Application for a non-material amendment following a grant of planning permission.

Proposed house - Amendment & planning permission BE/135/07

BE/29/10

- Internal changes to WC & wet room
- French doors fully glazed
- 2 no Velux 'Sun Tunnels'

Project	Sheet
ADC/2/07	
Date	10D
02.11.2011	
Scale	
1:100 @ A1

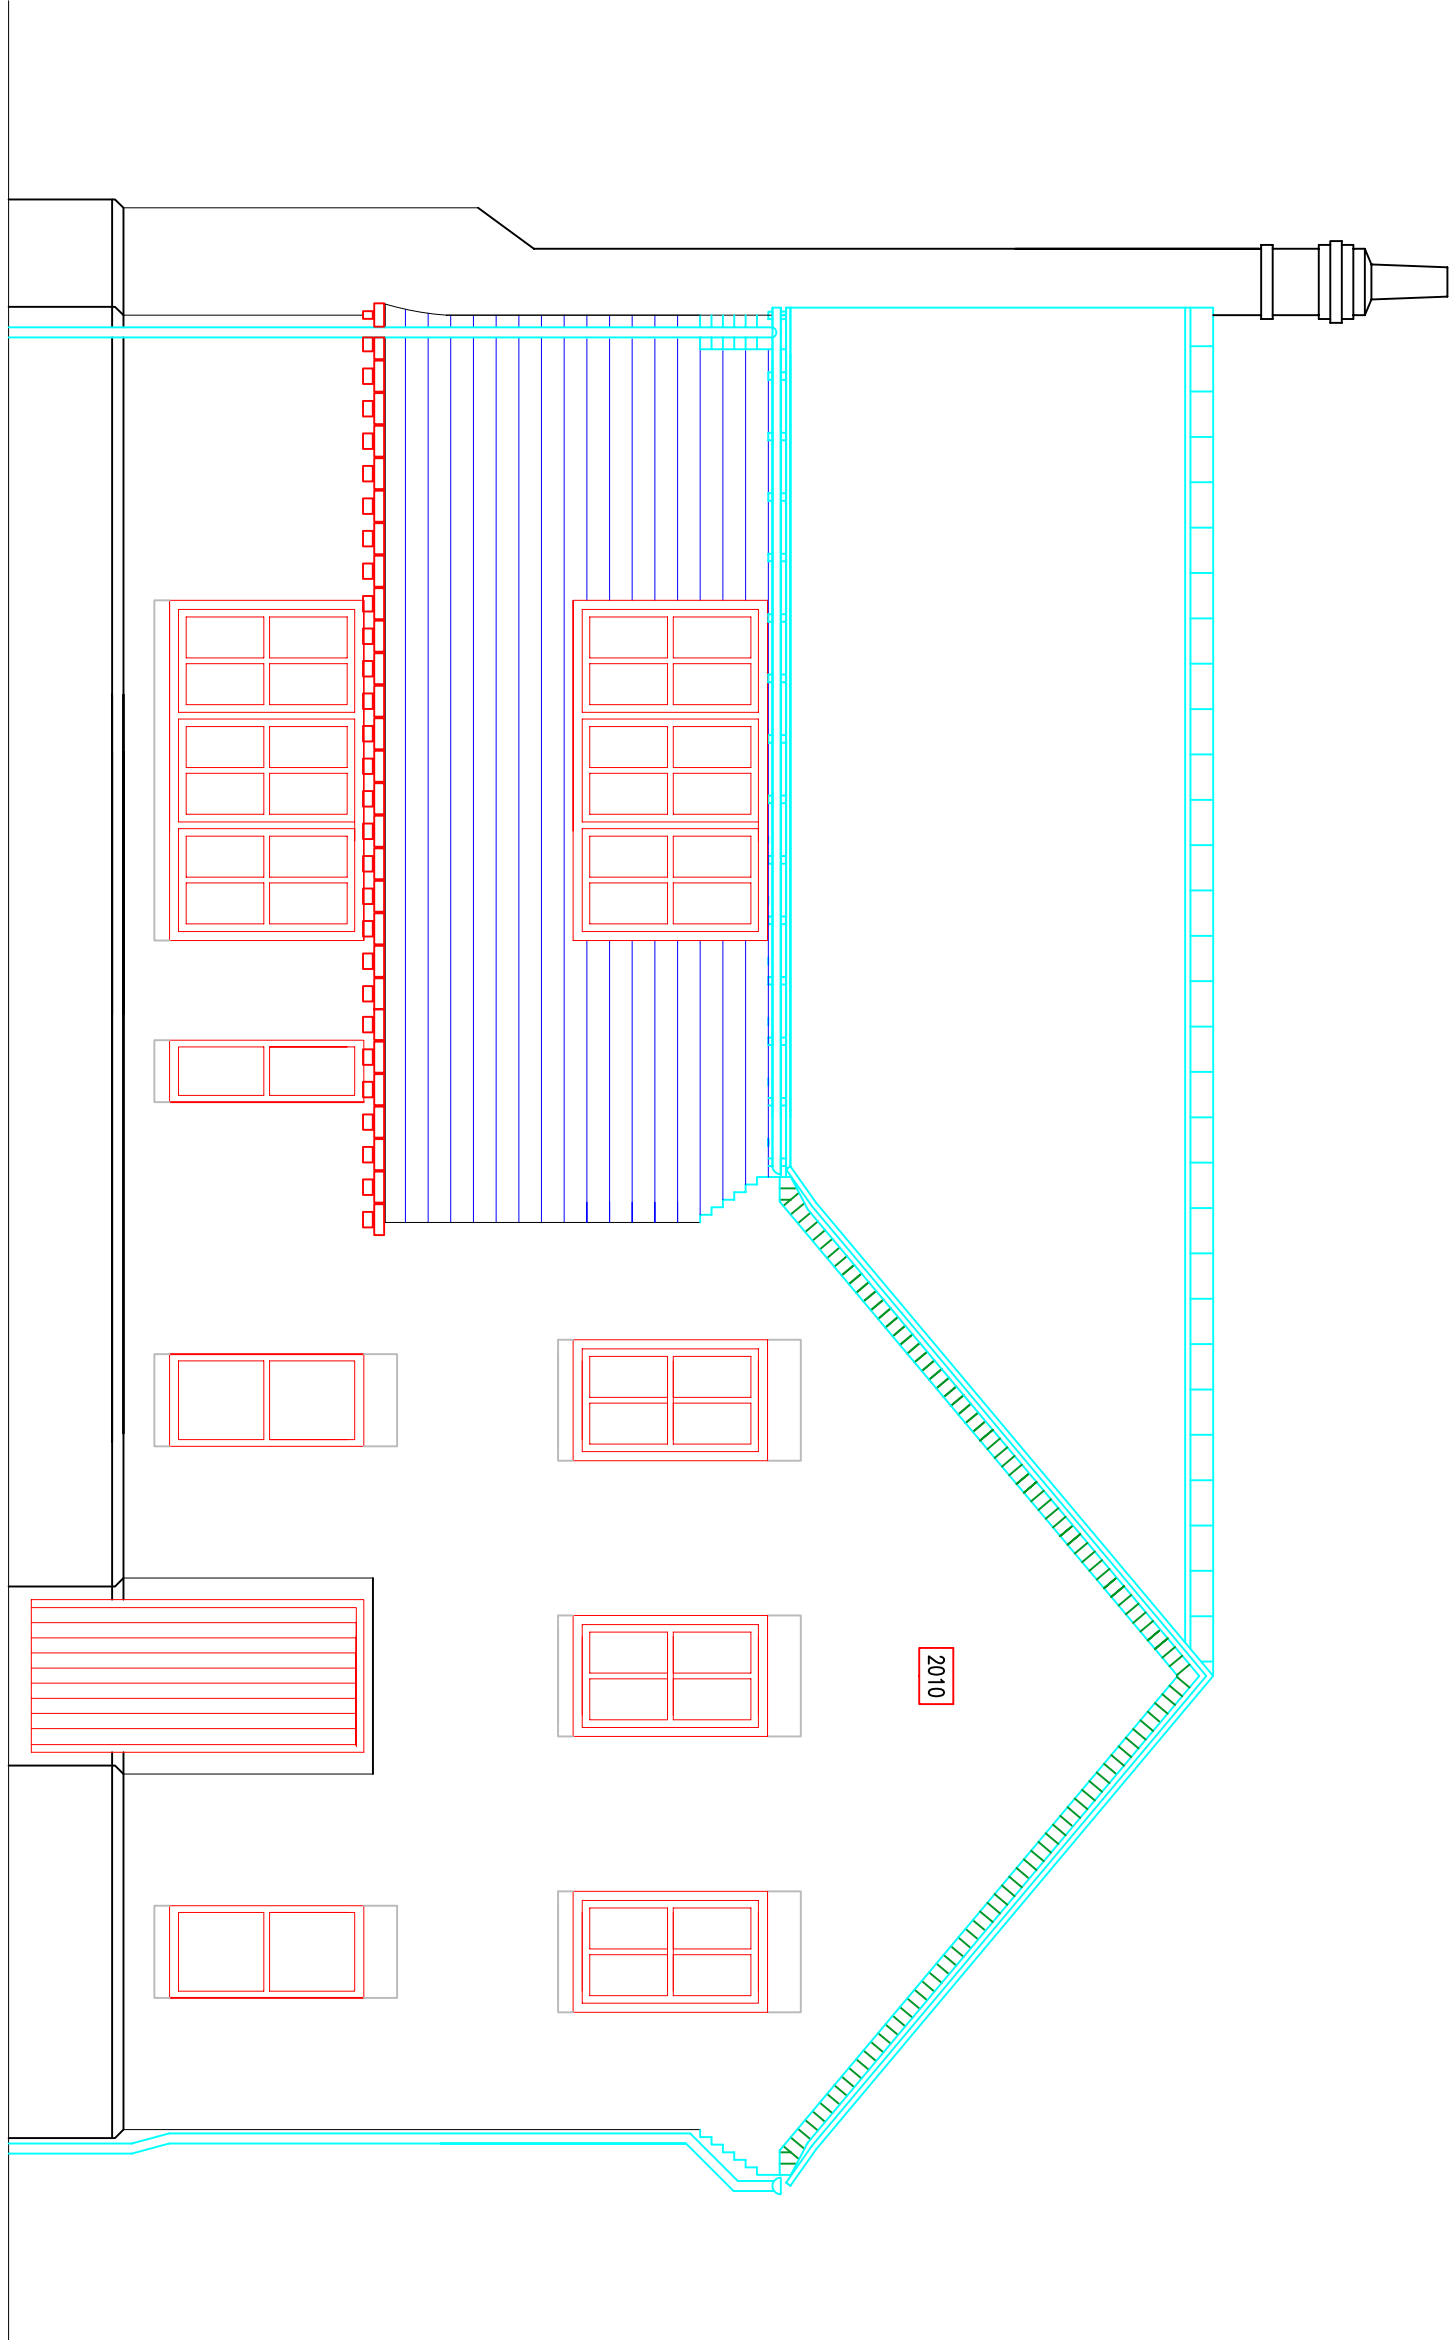
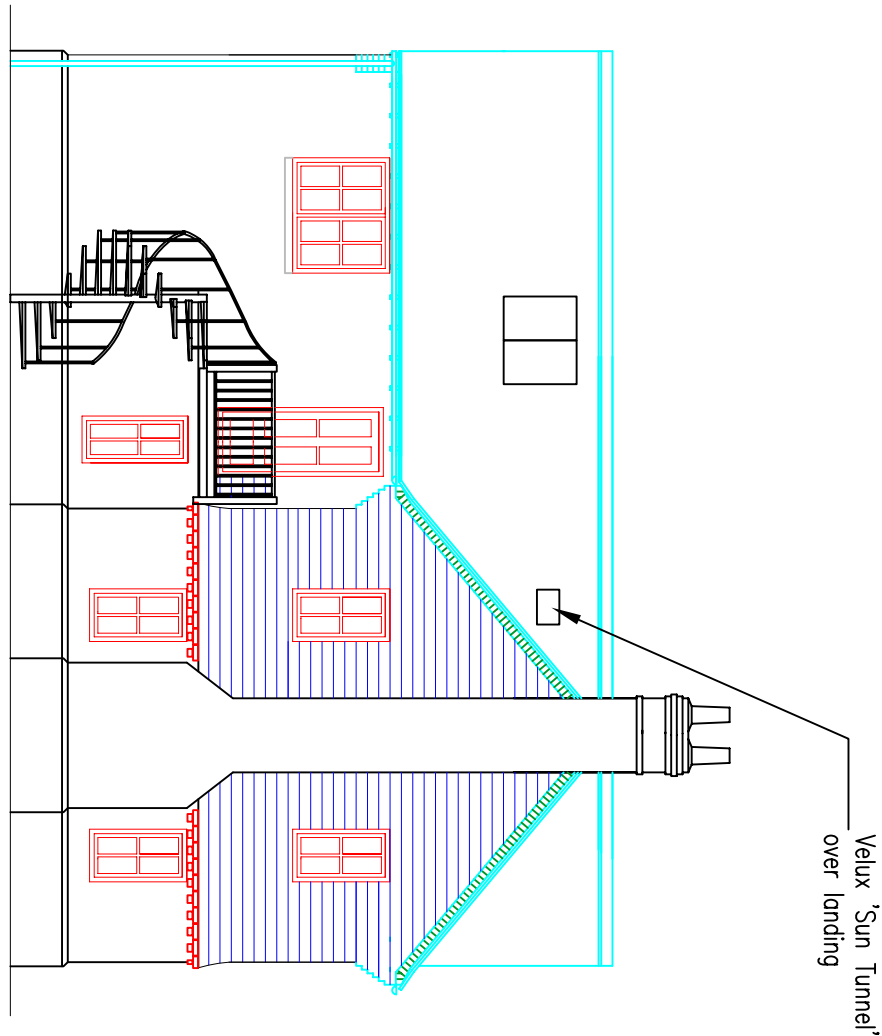
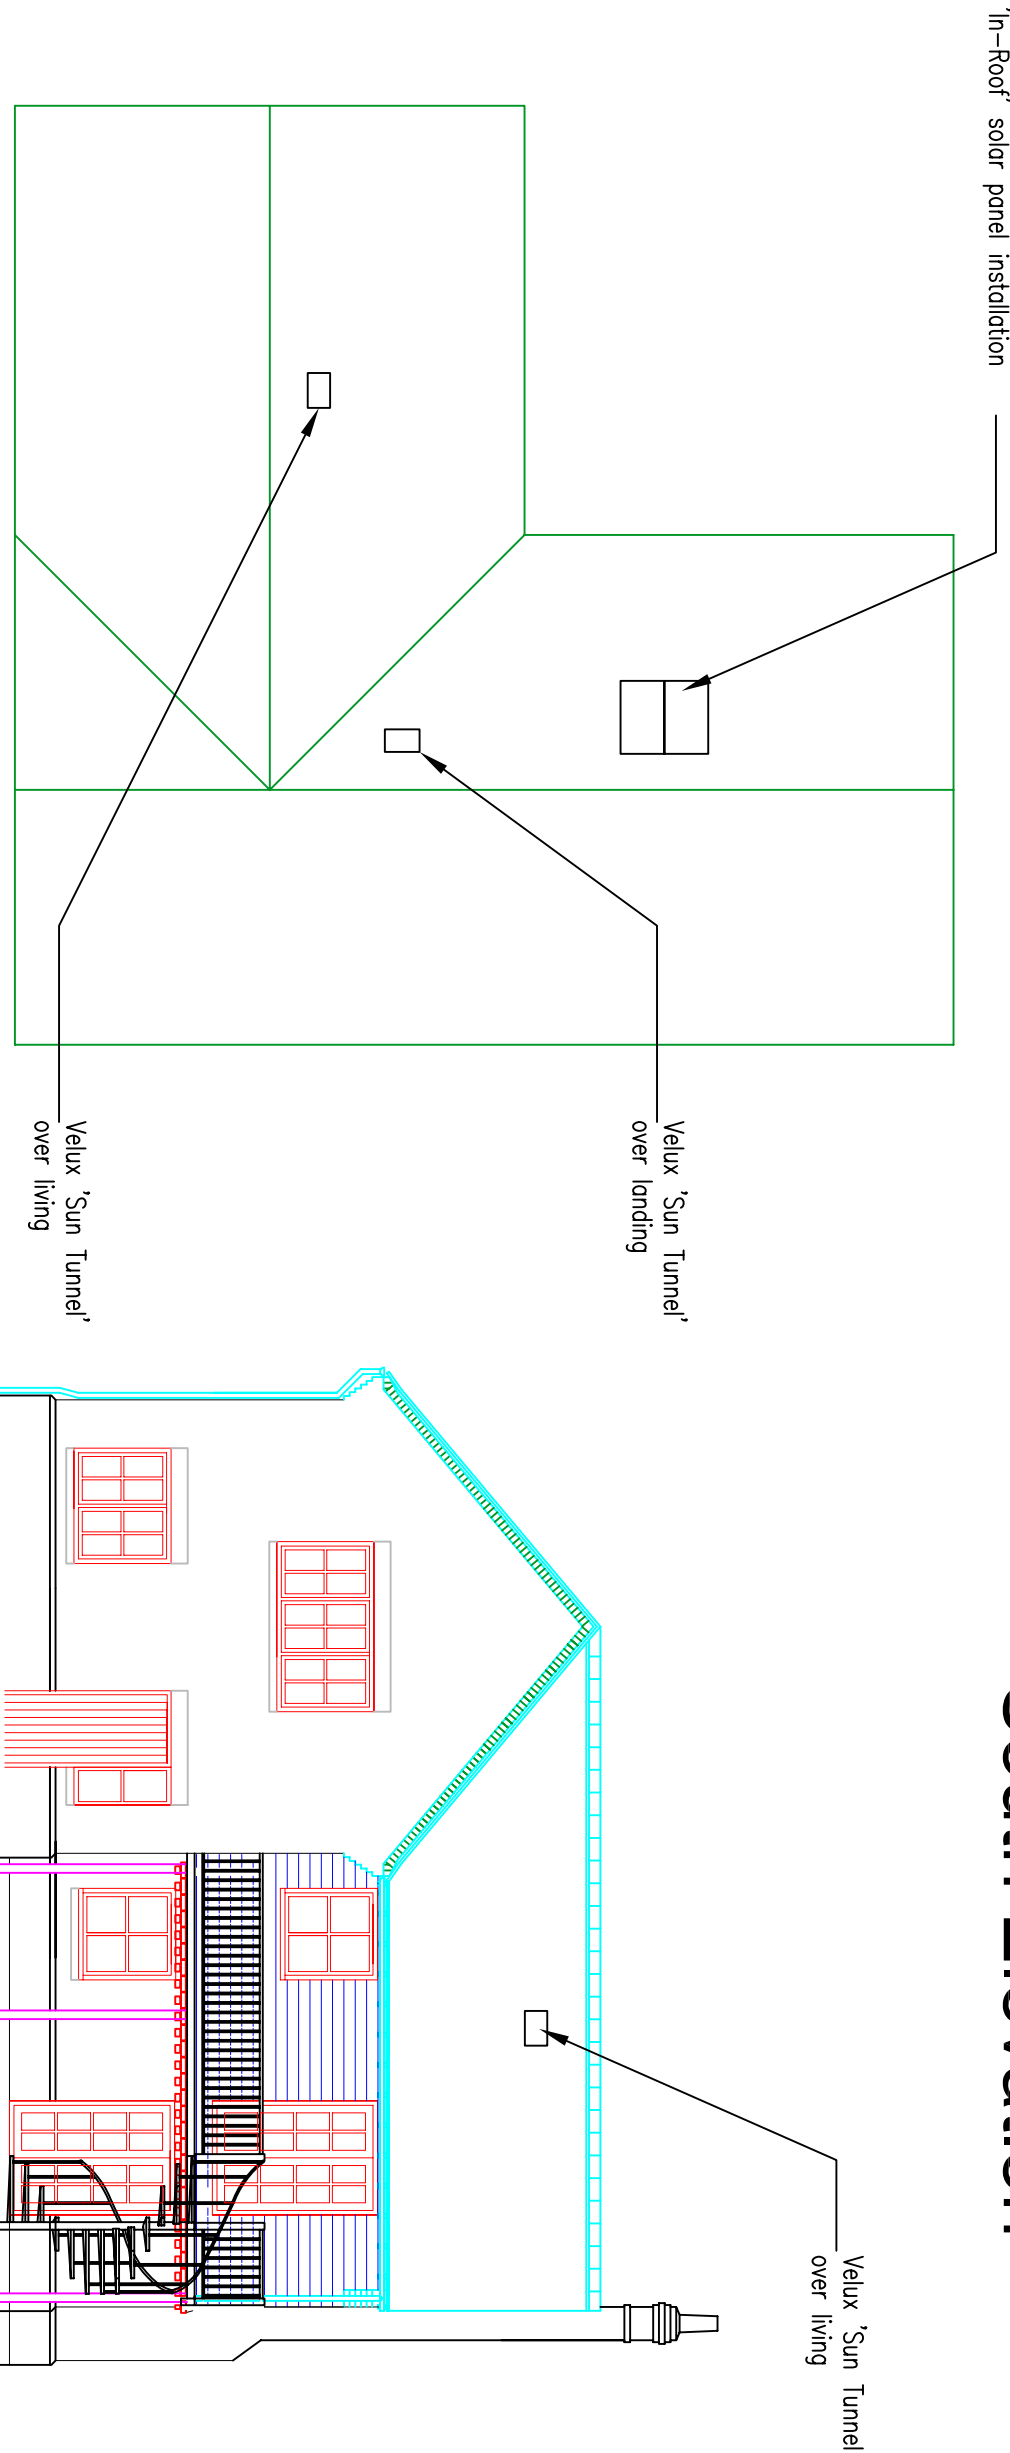
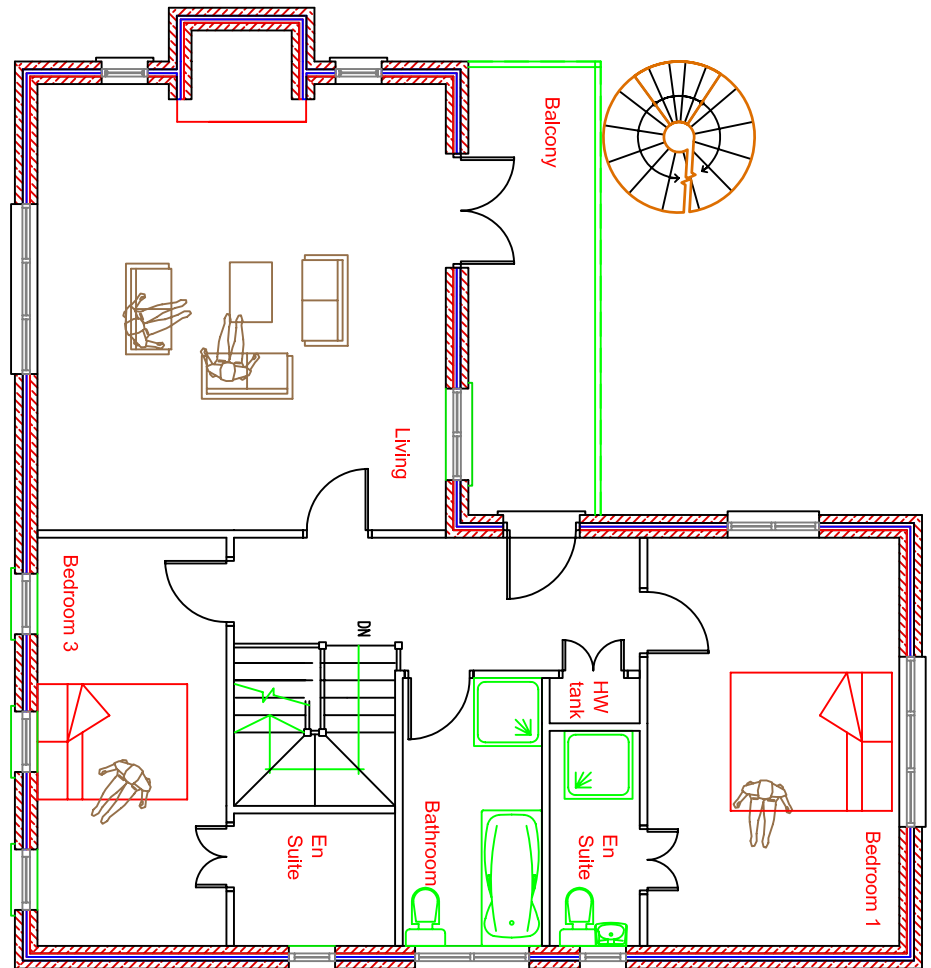
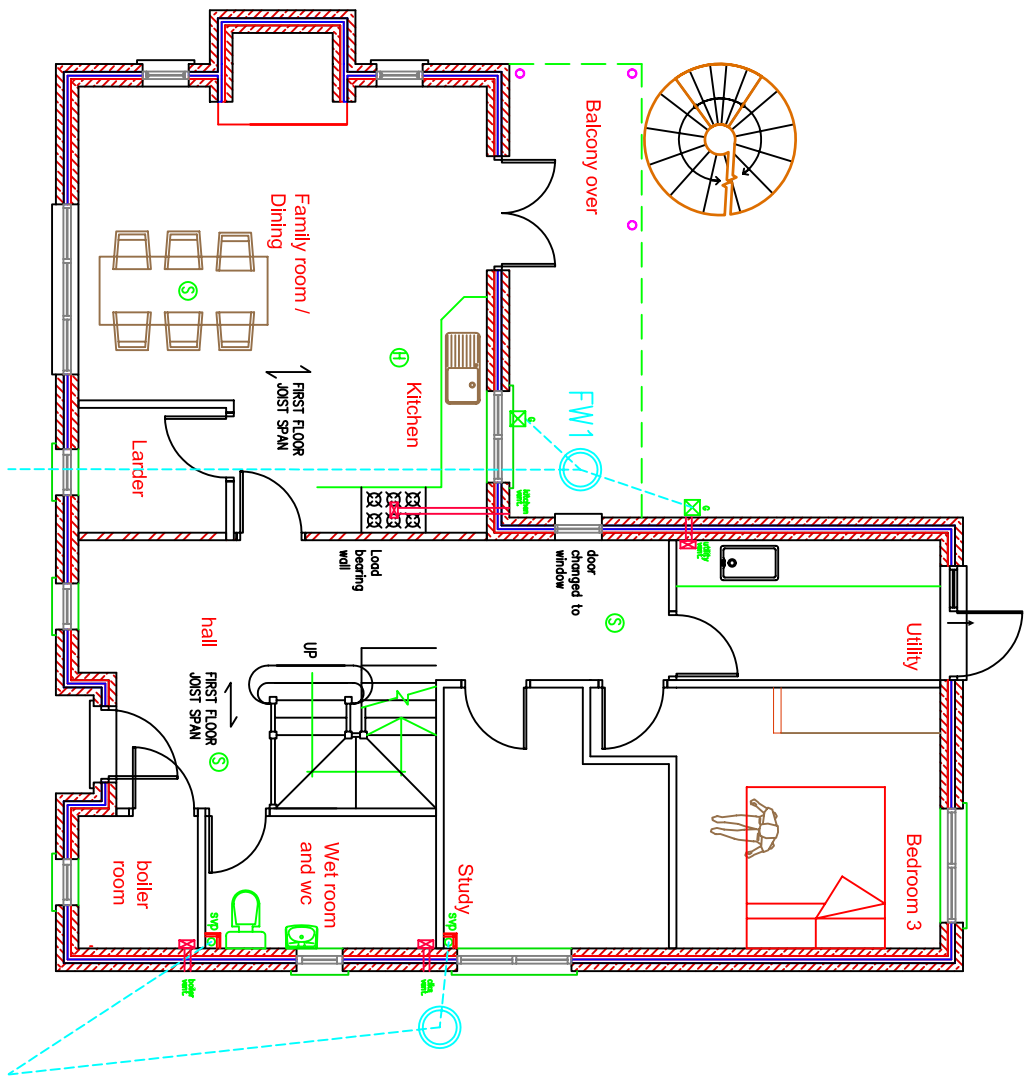
Old plan/drawing number(s):

10C

New plan/drawing number(s):

10D

Improve appearance & light to dwelling.
